# Construction Drawings (PlansProfiles)\_v1.pdf Markup Summary

## 8-29-2022

Cursory comments

INTERSECTION DETAIL

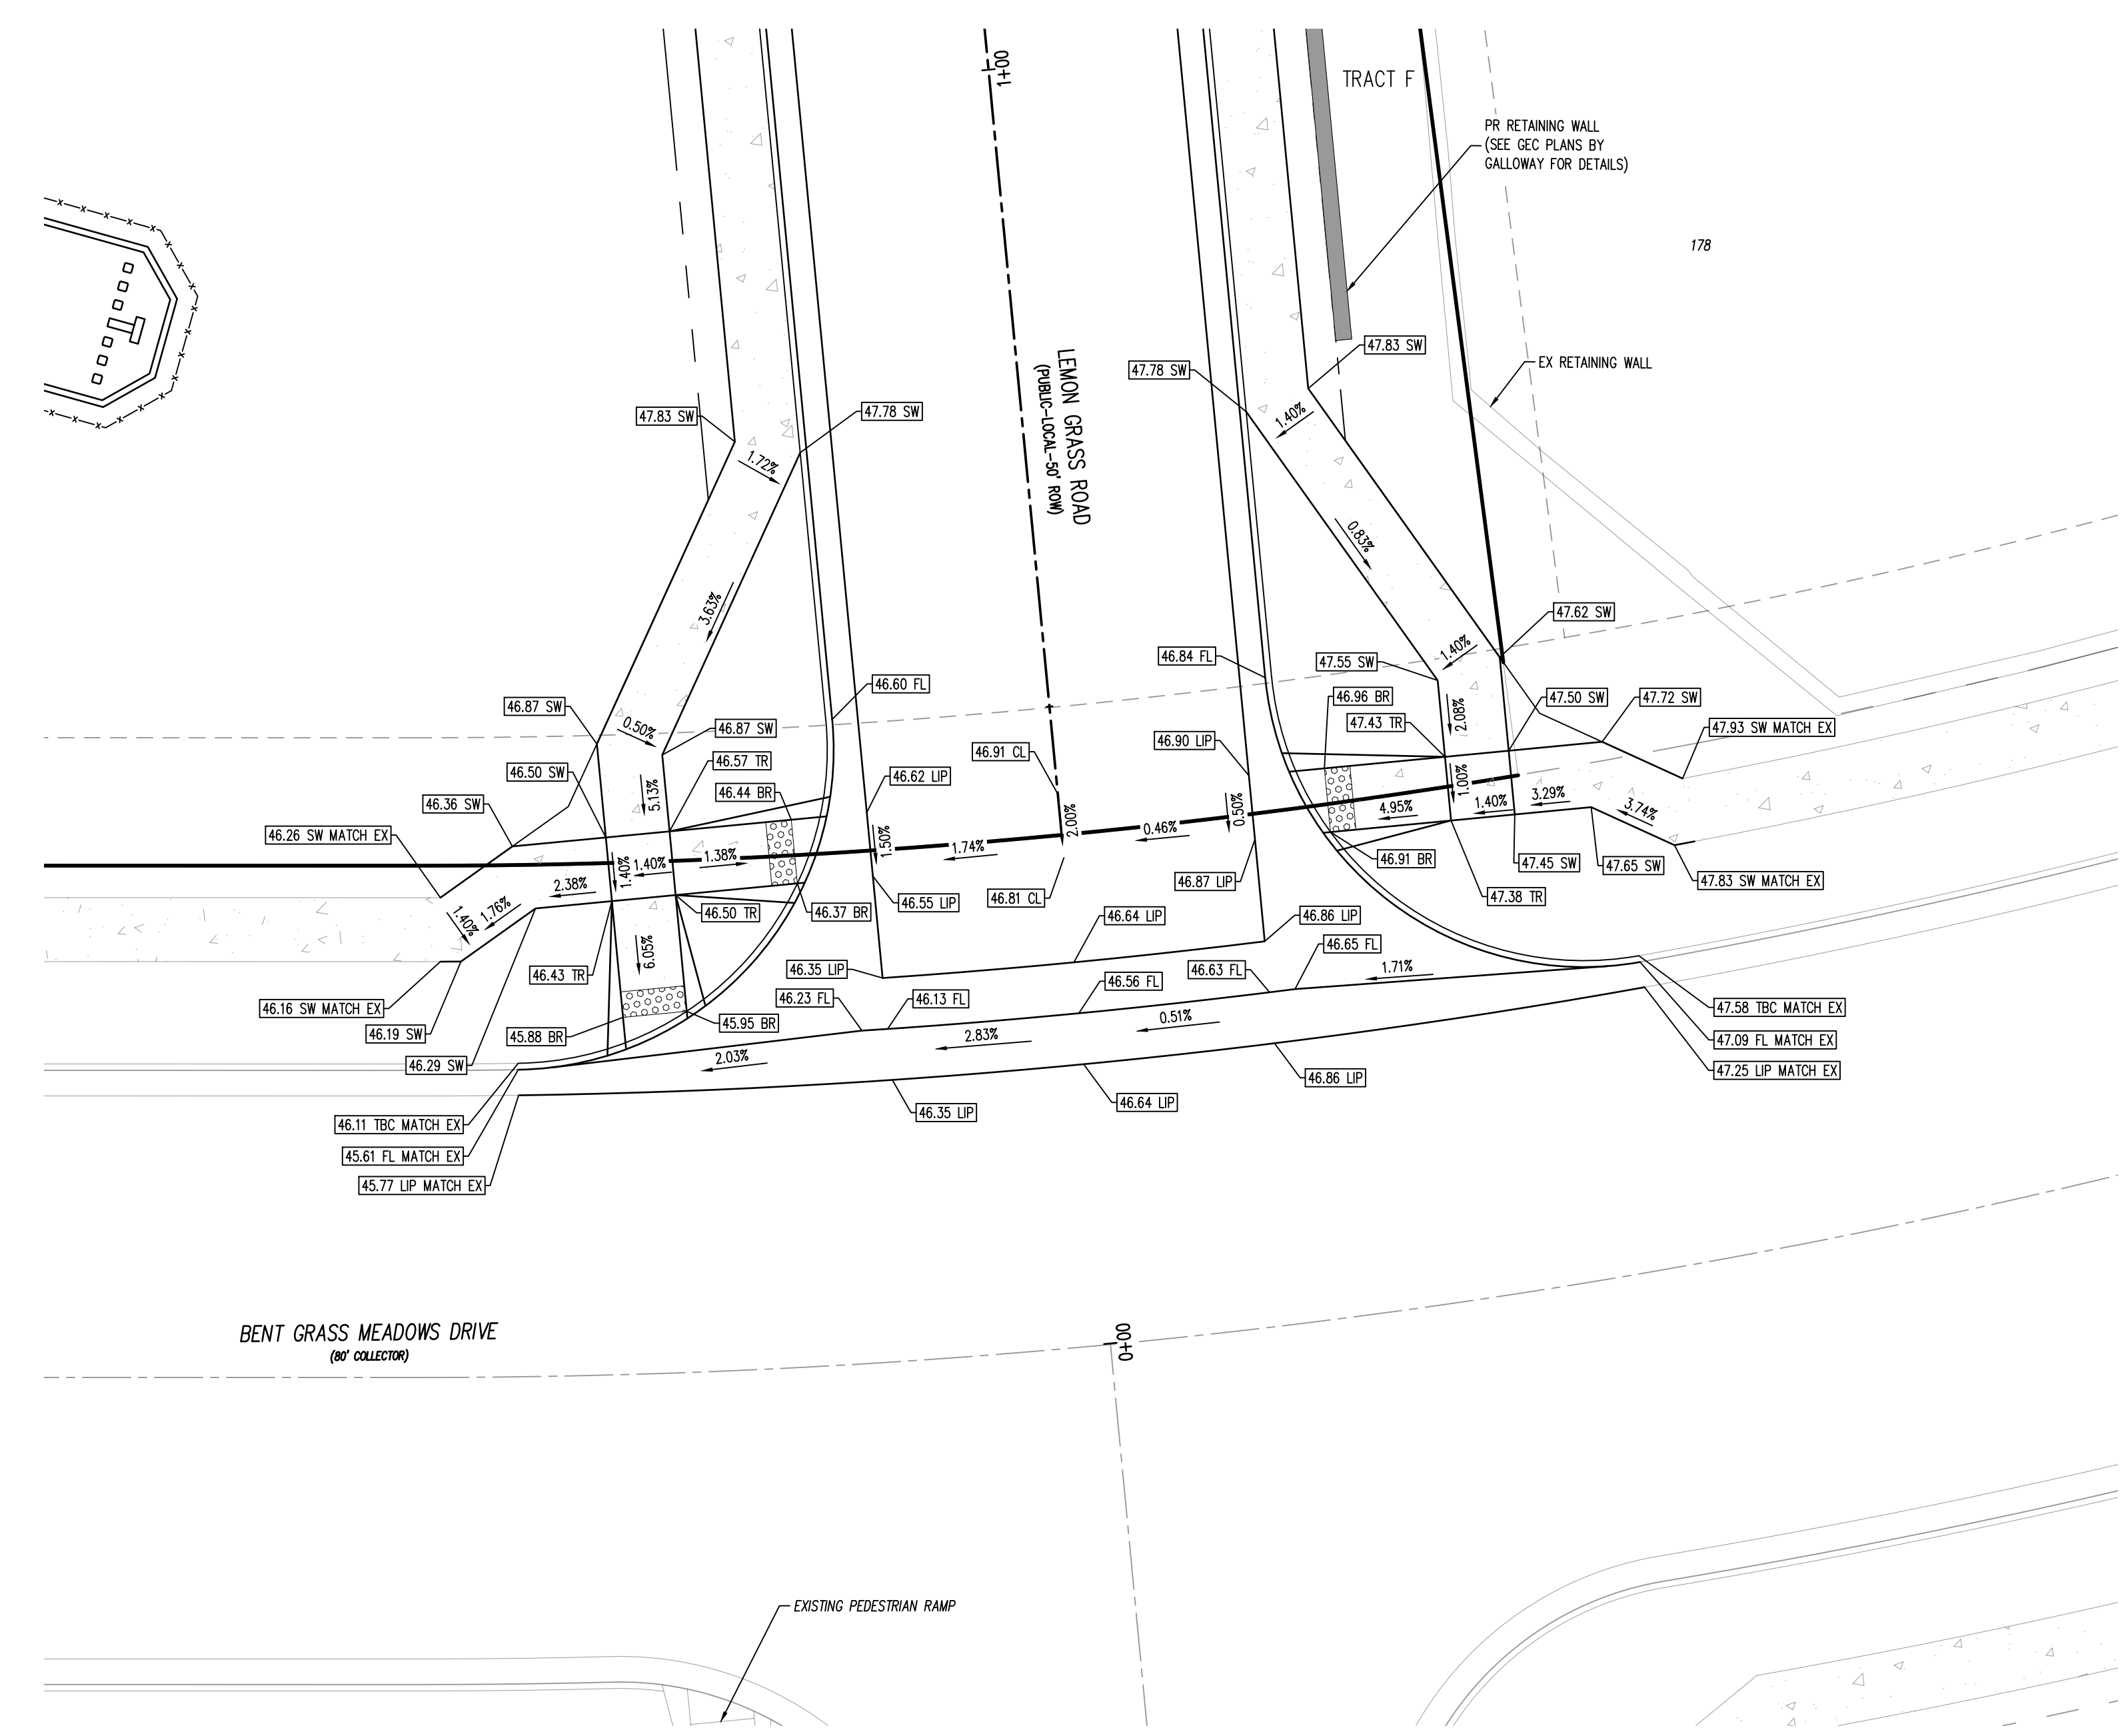
Adjust design per ECM 6.3.1.G

Label existing ramp (if so)

Show and label storm drain crossing
